**Addendum No. 1**

RE: Contract ID C202931  
WBS # 14CR.10451.5, Etc.

**Henderson County**

US-25 From South Carolina State Line To SR-1858 And  
3 Sections of Secondary Roads

PROJECT REFERENCE NO.		SHEET NO.	
14CR.10451.5		4 OF 8	
STATE PROJECT	F.A. PROJECT NO.	DESCRIPTION	
14CR.10451.5

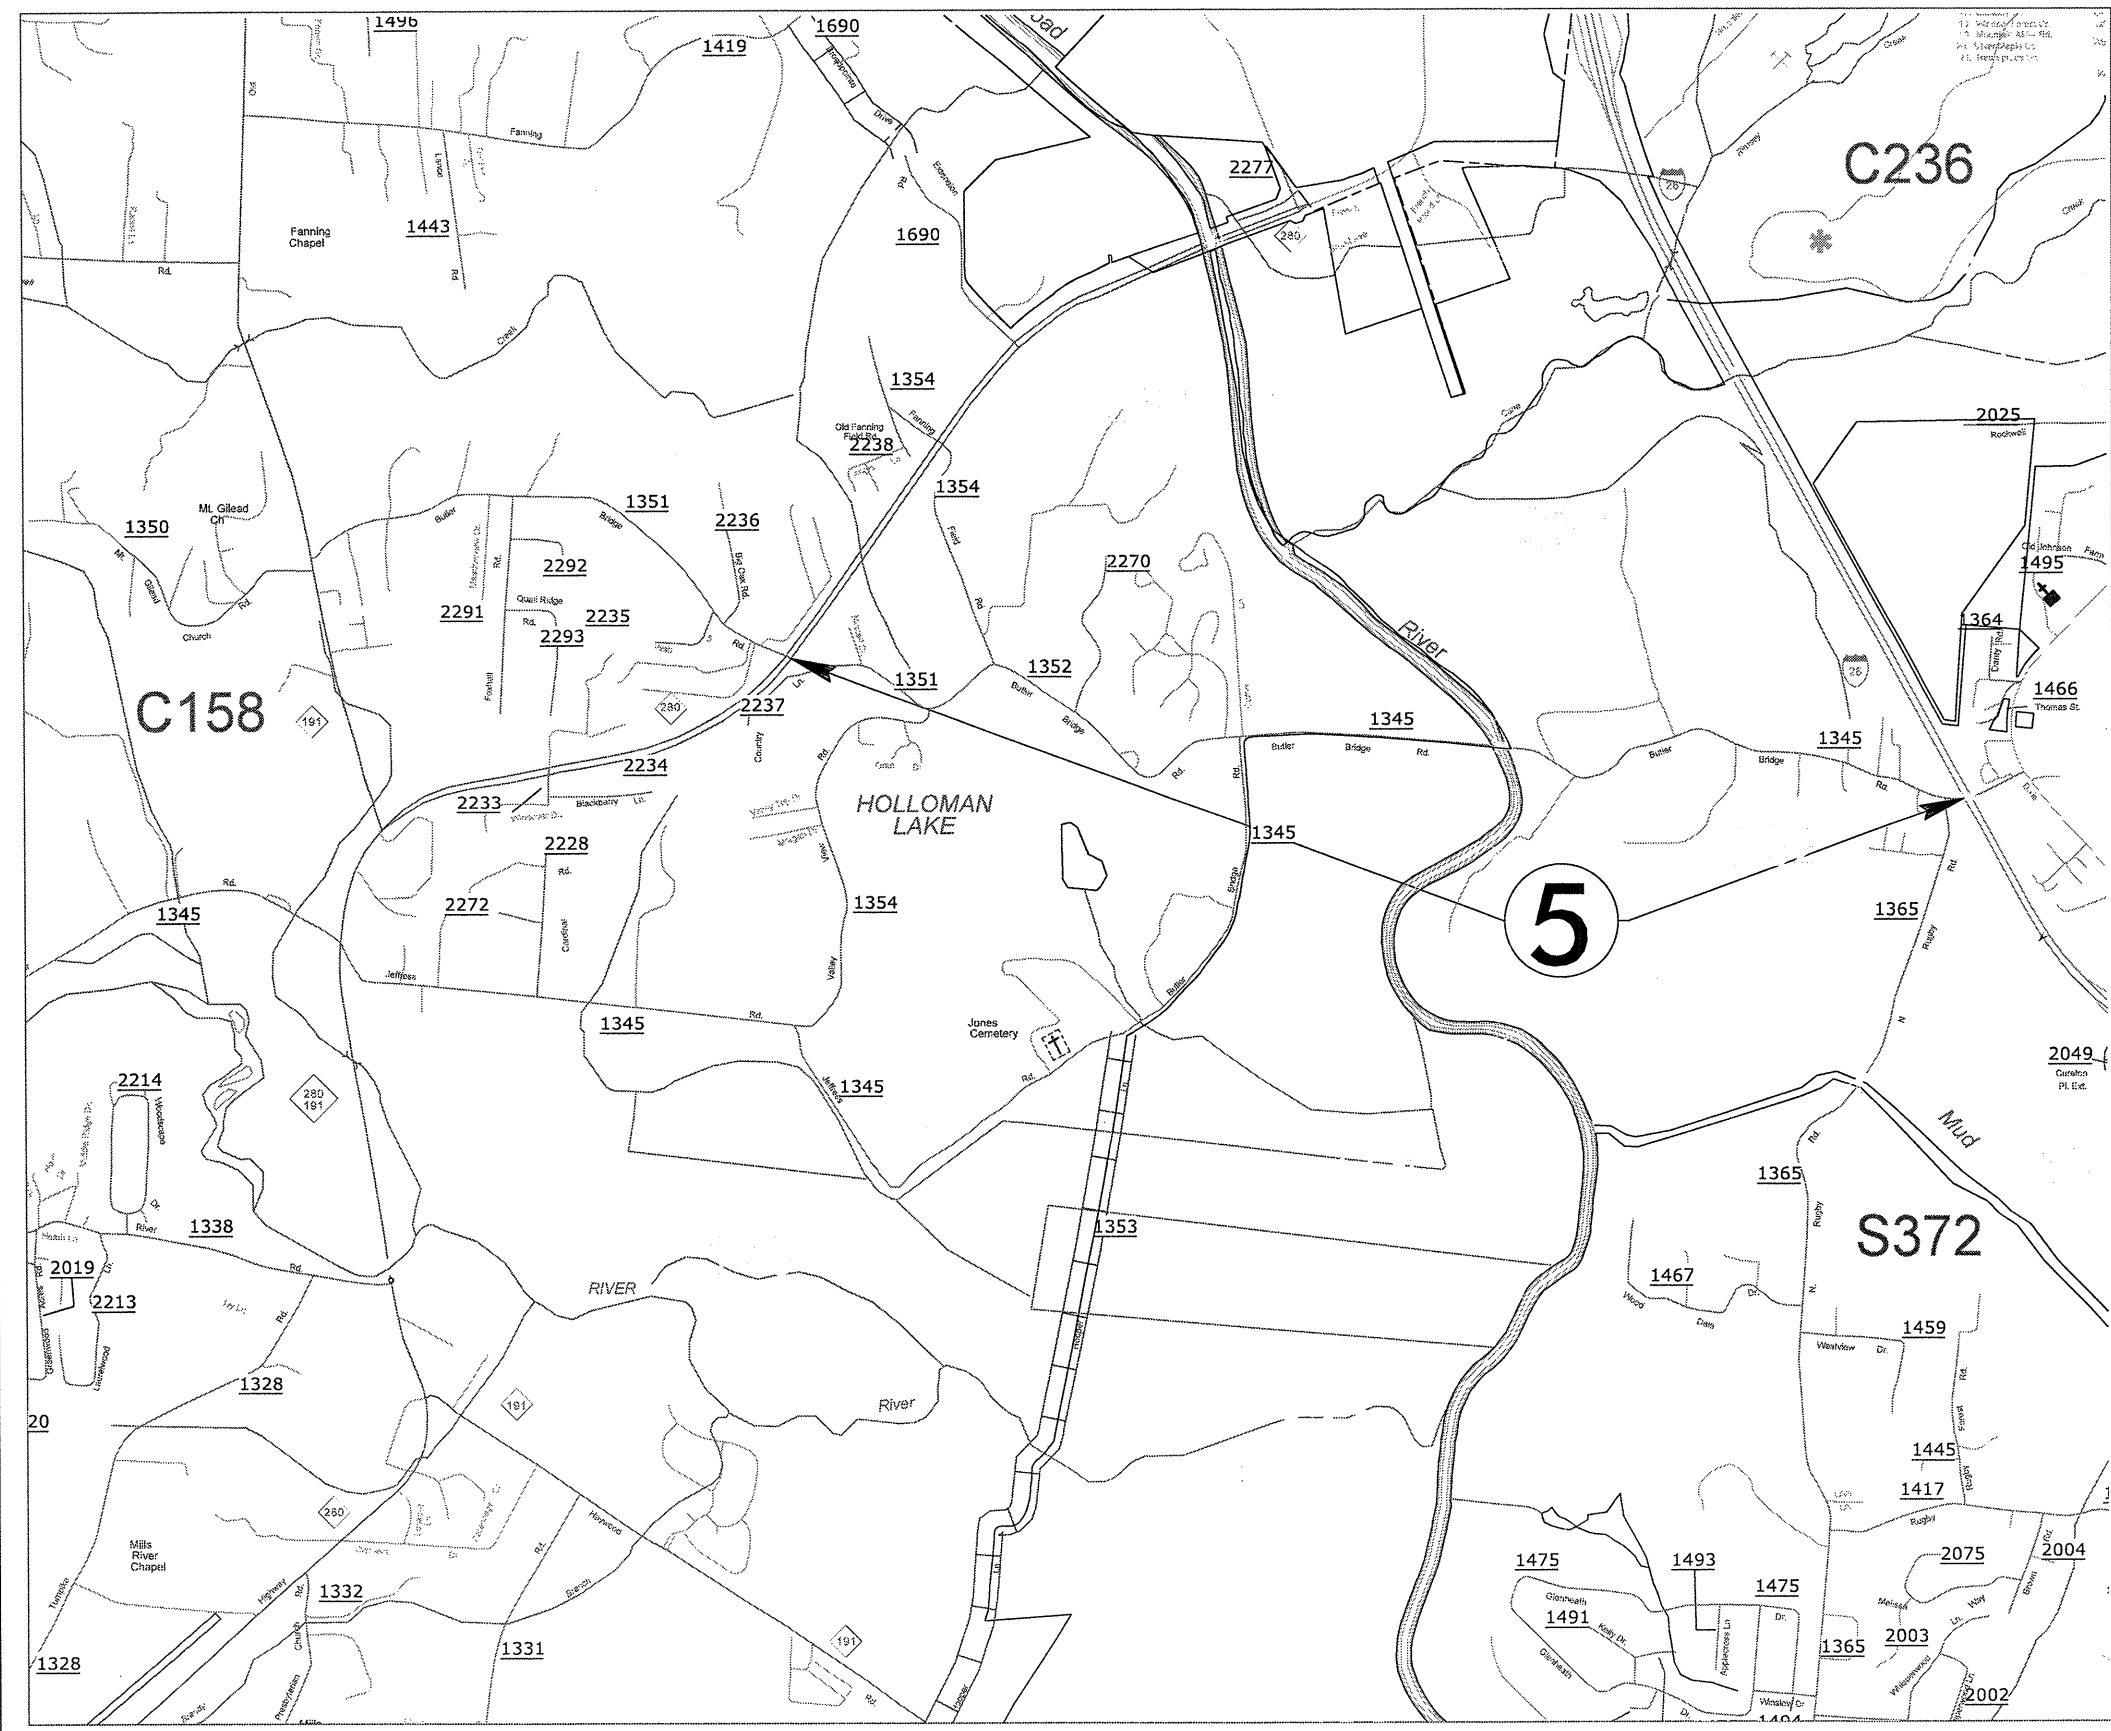
On Sheet No. 4 the note has been revised. Please void Sheet No. 4 in your proposal and staple the revised Sheet No. 4 thereto.

PROJECT REFERENCE NO.		SHEET NO.
14CR.10451.5		6 OF 8
STATE PROJECT	F.A. PROJECT NO.	DESCRIPTION
14CR.10451.4

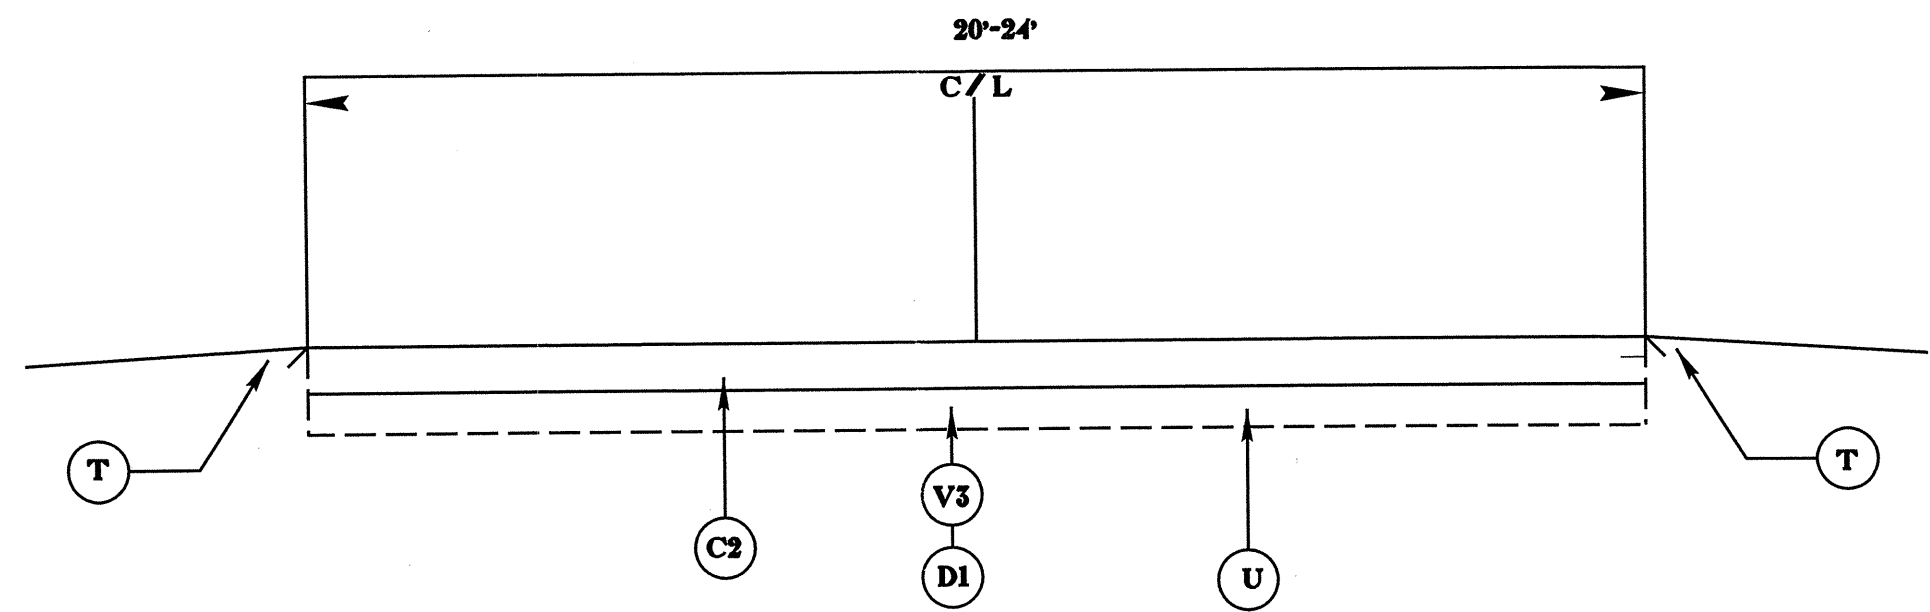
On Sheet No. 6 the description for the symbol "D1" was revised. Please void Sheet No. 6 in your proposal and staple the revised Sheet No. 6 thereto.
